From:  Dawn Appleton 
Sent: 25 March 2014 14:38
To: Simon Davis
Subject: RE: West Barn, Norton

Further to our telephone conversation yesterday regarding West Barn in Norton, our client wishes to obtain further amendments to the original planning approval AL/92/08 and the subsequent amendments approved under AL/28/12. You will be aware that Unit 1 has been implemented in accordance with AL/28/12 but further amendments are now sought to convert the remainder of the building. Internal changes are proposed which necessitate changes to the external appearance by the installation of additional windows.

REVISION			
Project		Conversion of existing barn at New House Farm, Norton Lane, Aldingbourne	
Drawing		Elevations	
scale	Date	Drawing No 11 / 53 / 21	
1:100	Jan 2014		
Drawn	Checked

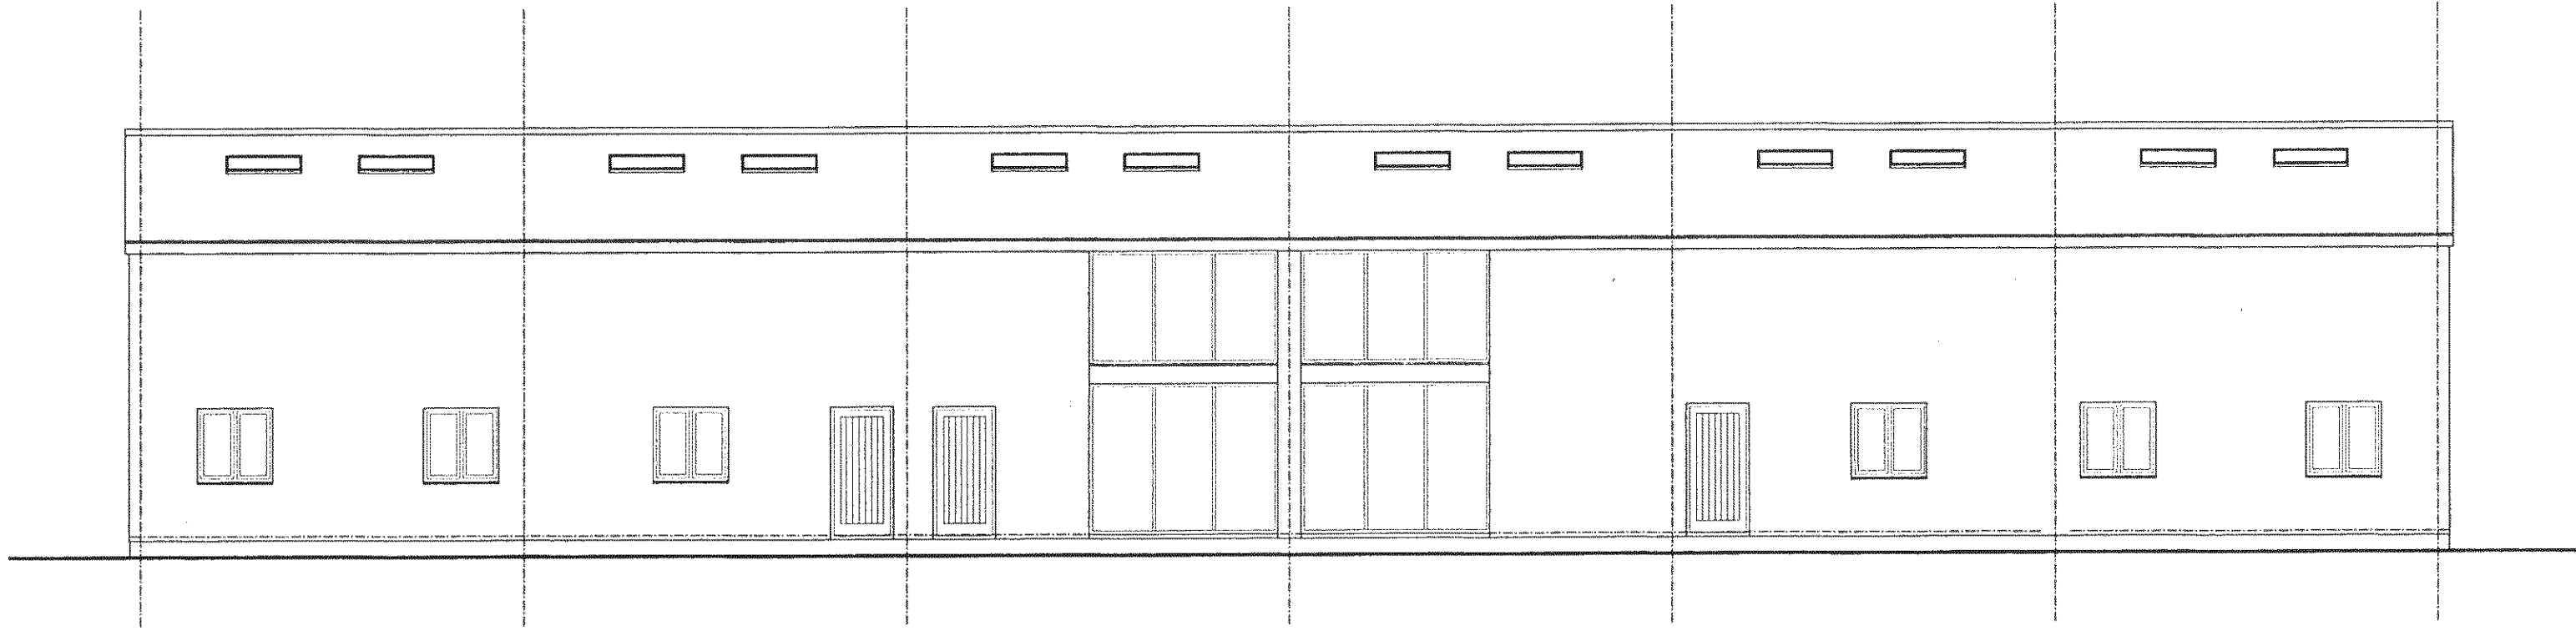
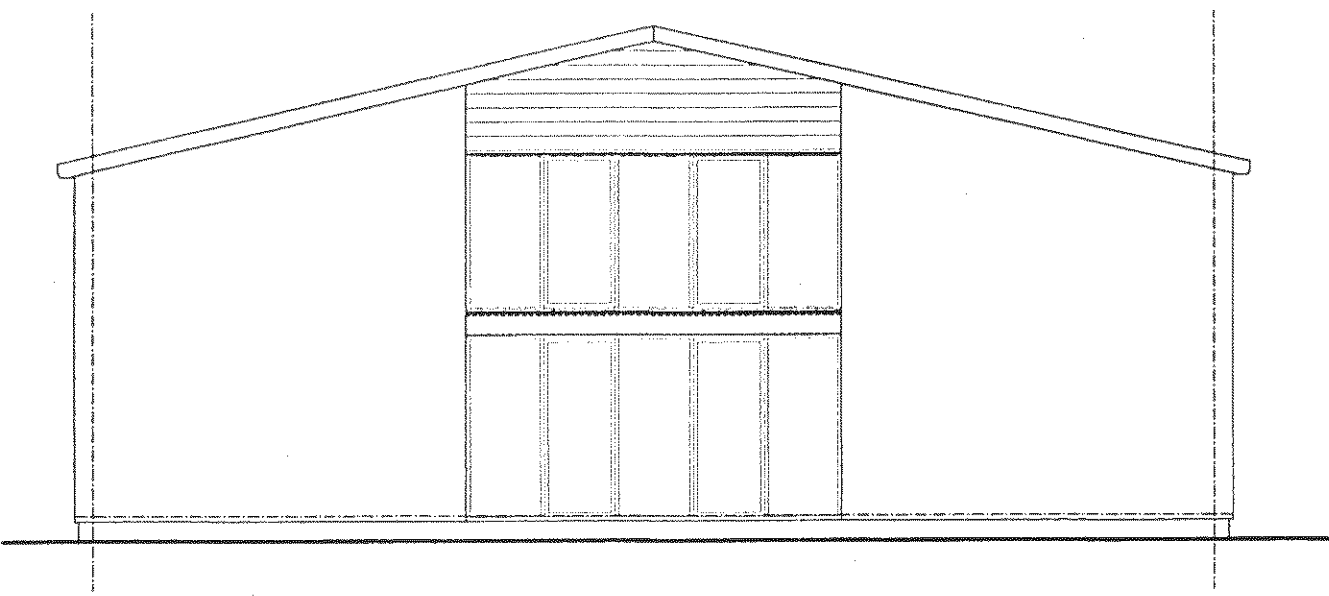
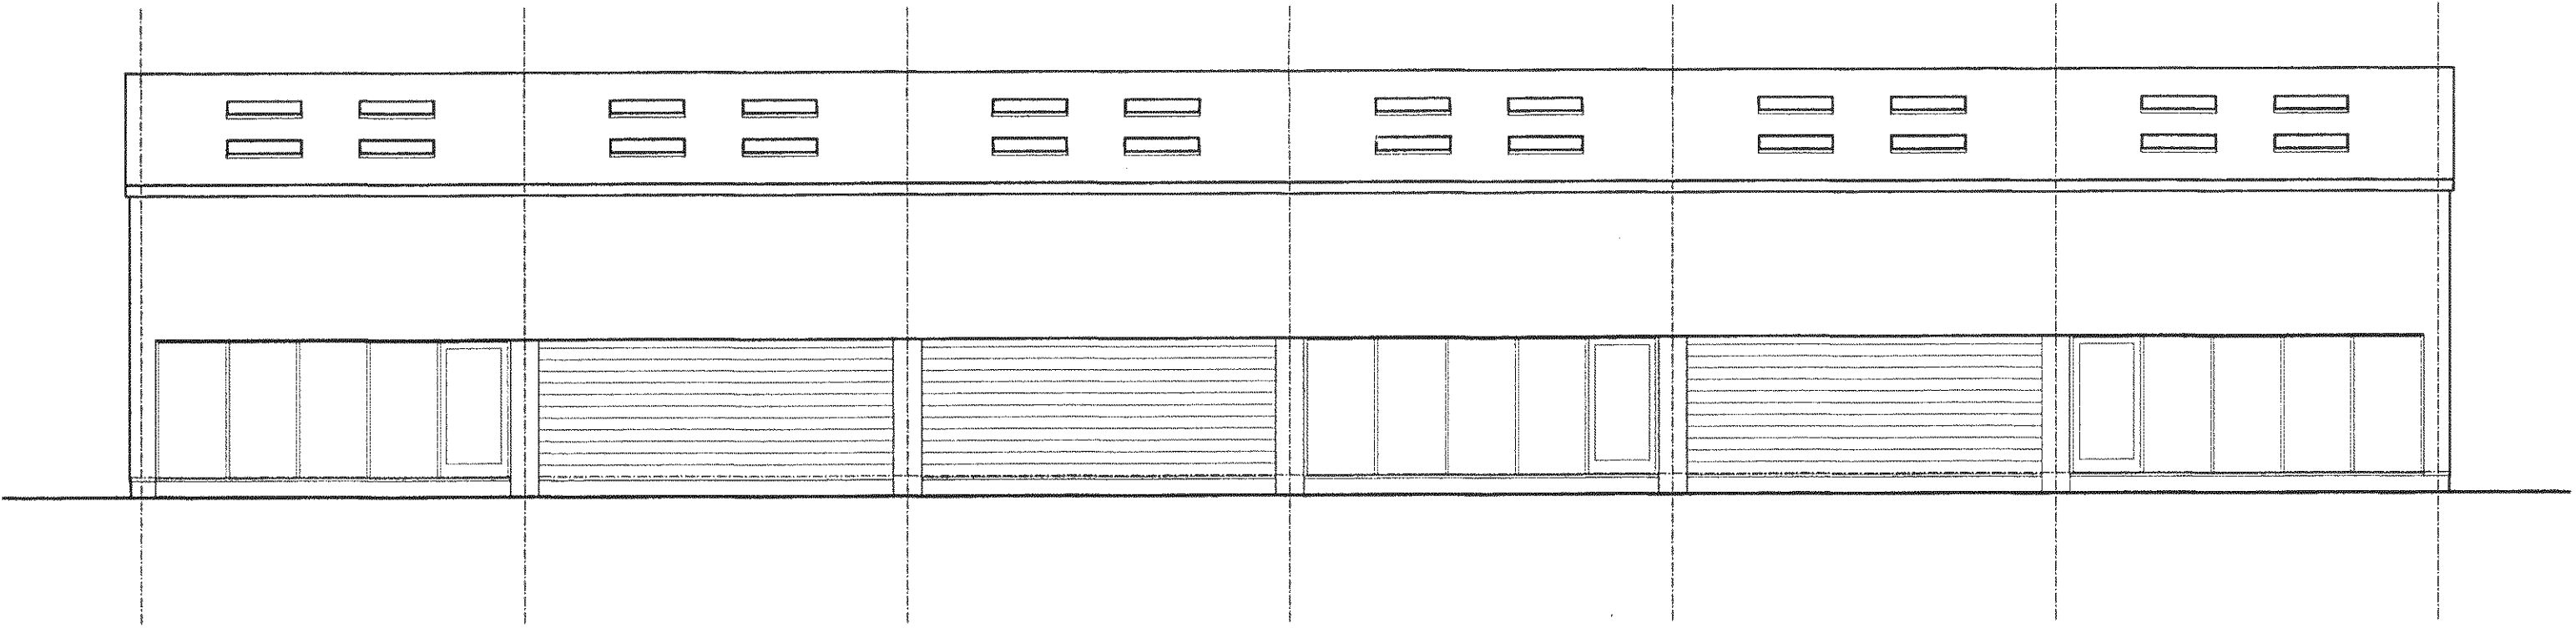
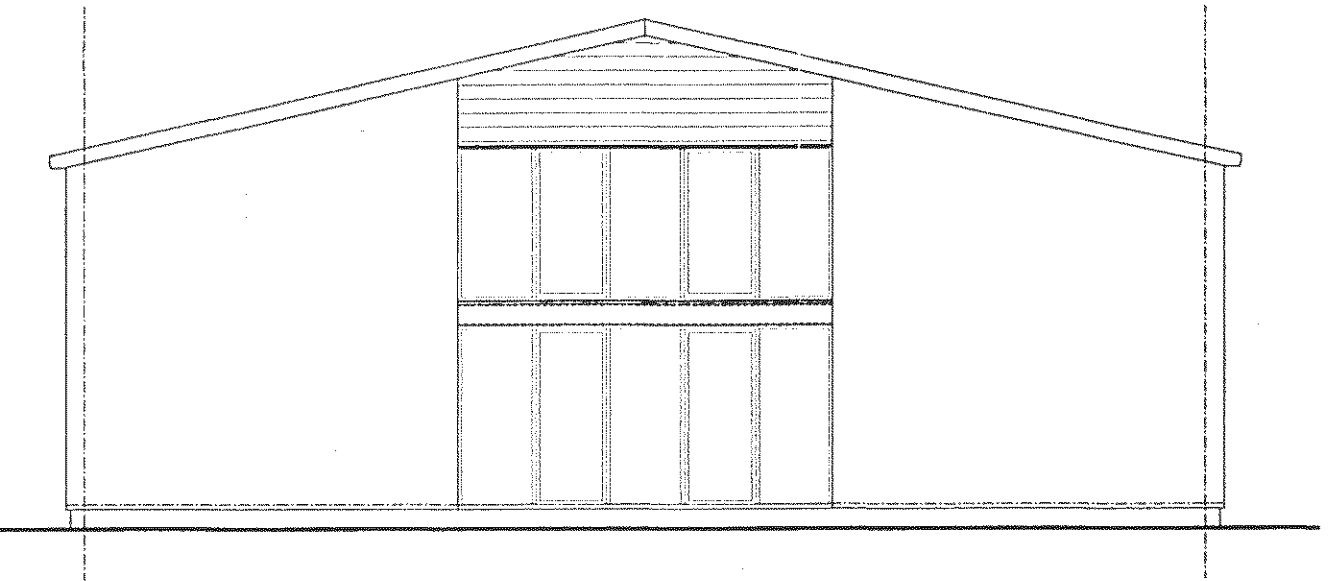
Yes I noted all of the new windows. I have no problem with the other elevations and consider that all of the changes could be dealt with by non-material amendment.

Thanks Simon, I just want to be clear though, there are new windows on the south and west elevations but assume from your comments that you are most concerned about the east elevation which, as you say, involves very little change.

I've now been able to compare the new drawings with the approved (AL/28/12) ones. I note that the only change to the east elevation (i.e. the one facing the neighbours) is the removal of one block of windows. On that basis and with regard to our guidance on non-material amendments, I do not consider the changes to be material. You should therefore seek to make a non-material amendment application. Please feel free to mention me when making the application.
